Our Ref: AL/23/20/HH

**Town & Country Planning Act 1990 (as amended)
Town & Country Planning (Development Management Procedure) (England) Order 2015
Application for Householder Planning Permission**

Development Single storey ground floor rear extension and new roof to provide habitable accommodation.
Location Innisfree 26 Belle Meade Close Woodgate Aldingbourne

Proposed Block Plan

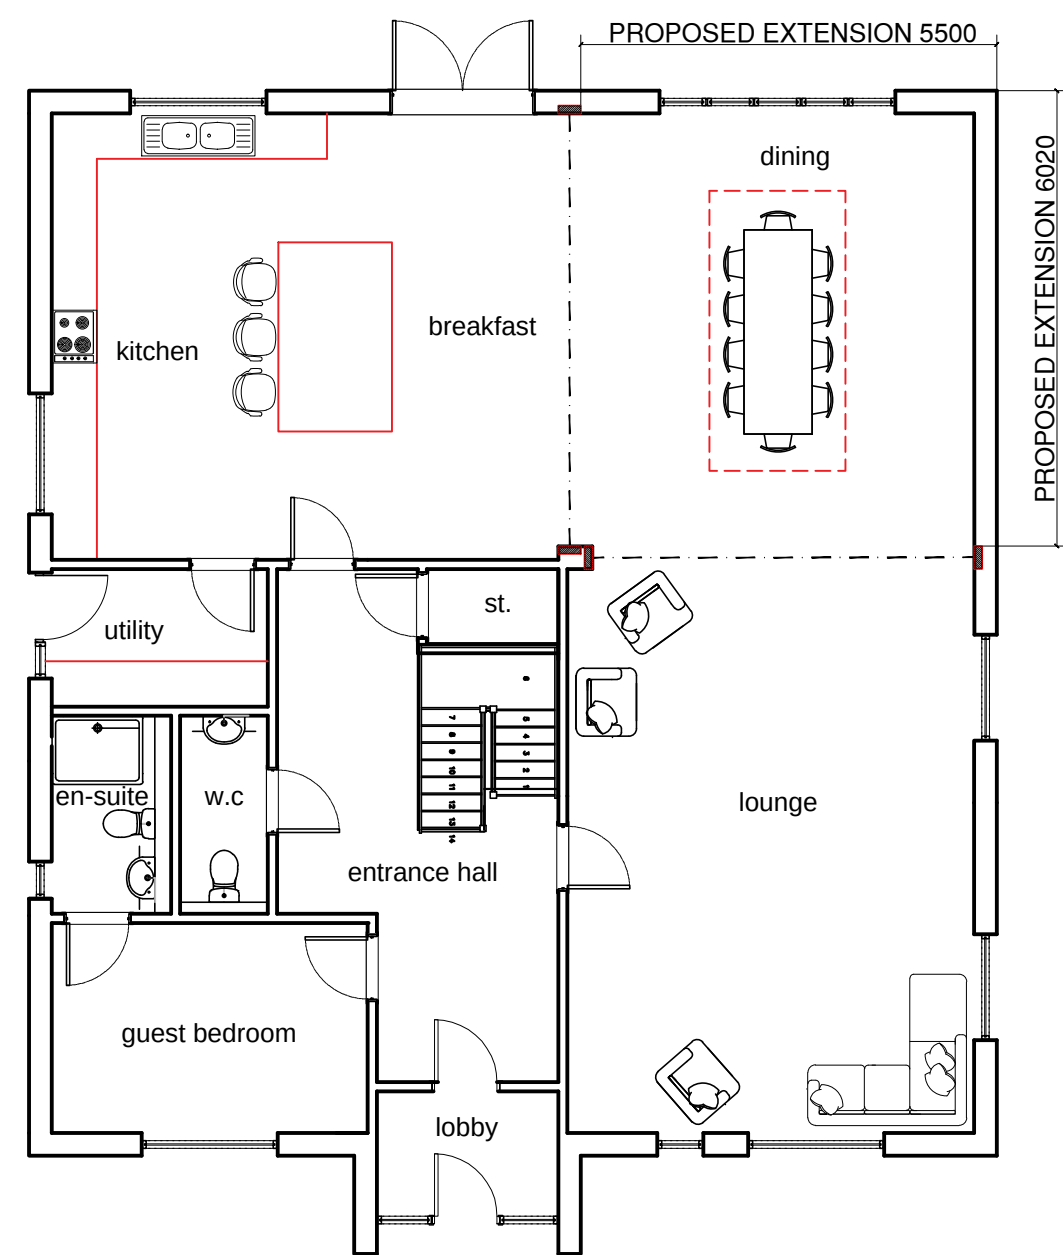
Block Plan

You are required to annotate the dimensions from each side of the proposal to the site boundary.
